Conversion & change of use of retail unit (A1 Shops) to 2 No. residential units (C3 Dwelling houses). This application affects the character & appearance of the Arundel Conservation Area.

67/69 Tarrant Street & 2A Arun Street Arundel

Thank you for your internet representation made on 5th April 2019 which has been recorded as '**support**' with the comments as follows:

EXISTING NORTH ELEVATION
67-69 TARRANT STREET

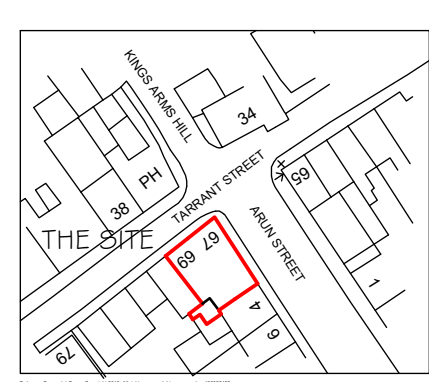
Whilst there is no planning control, the applicant might consider the replacement of the two existing inappropriate modern doors containing fixed fanlights and located on the north and east elevations with more appropriate painted 4-panel timber doors which would add further enhancement to the appearance of the buildings.
